From: Clare Dales
Sent: 04 January 2018 15:42
To: Simon Davis
Subject: RE: Revised plans AL/129/17/PL

As mentioned earlier, please find attached substitute plans to remove the dormer windows to address comments from the Design Officer. I trust that this overcomes the objections.

scale	date
1:100 @ A3	October 2017
job no	drawing no
16078	02.03
	rev
	B

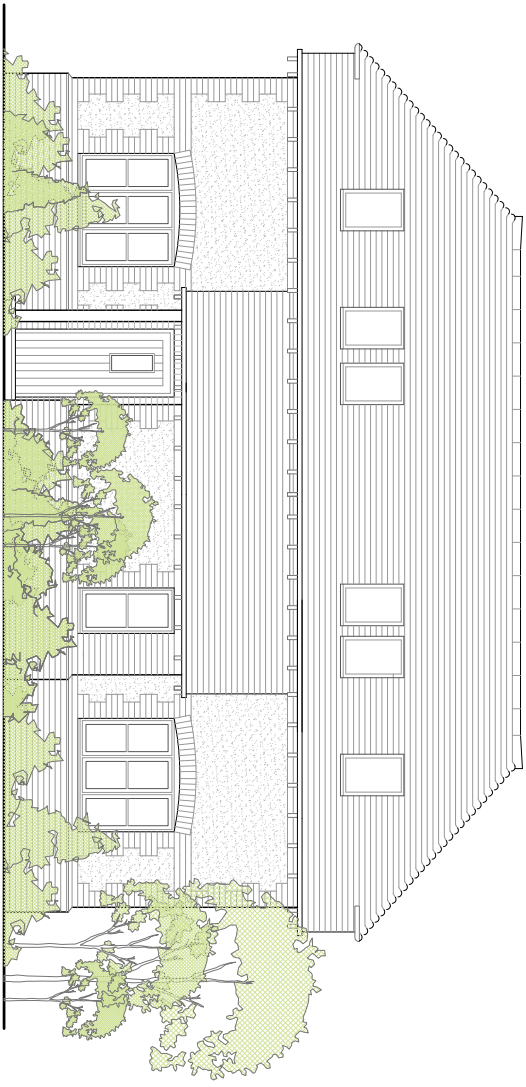
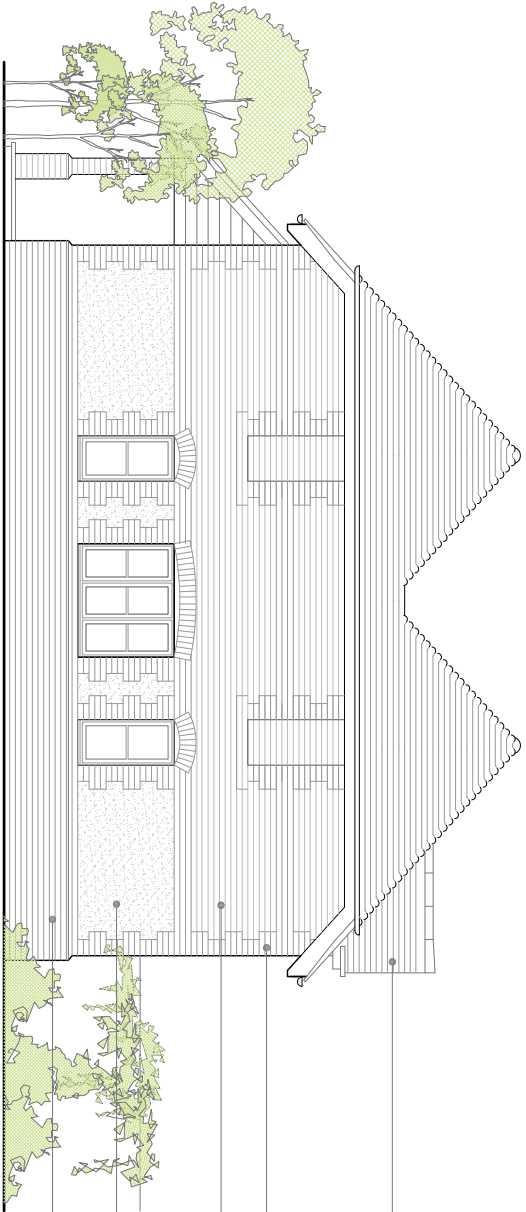
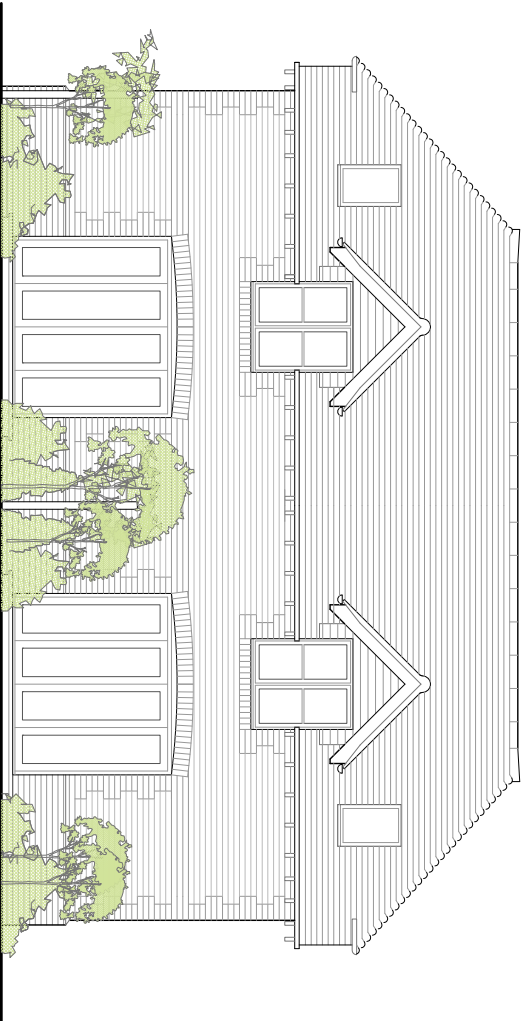
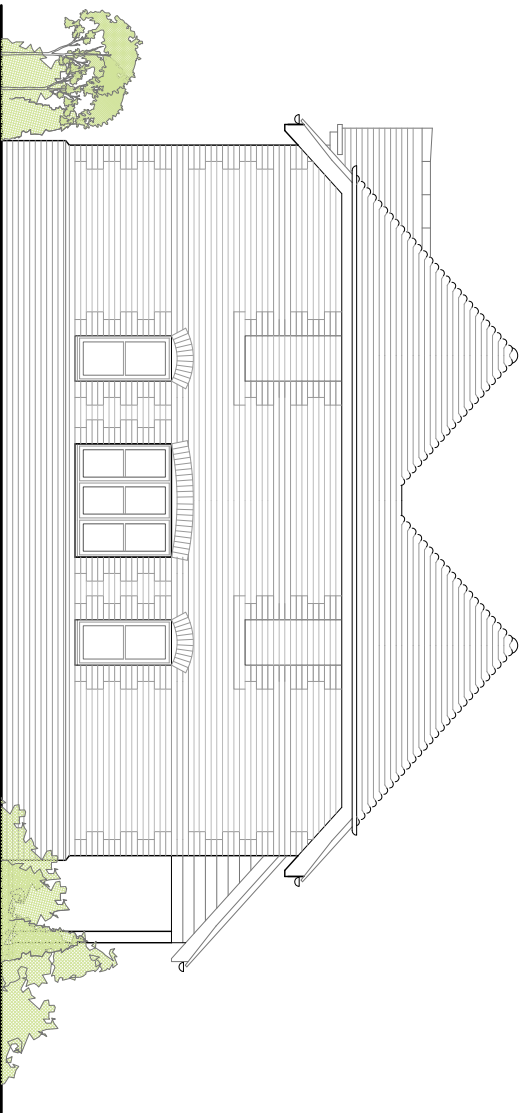
I think the alteration from dormers to rooflights makes the massing slightly less to the roofscape, but rooflights are incongruous to the area/adjacent Building of Local Interest, so I would say there is little net benefit to the alteration. The other concerns remain.
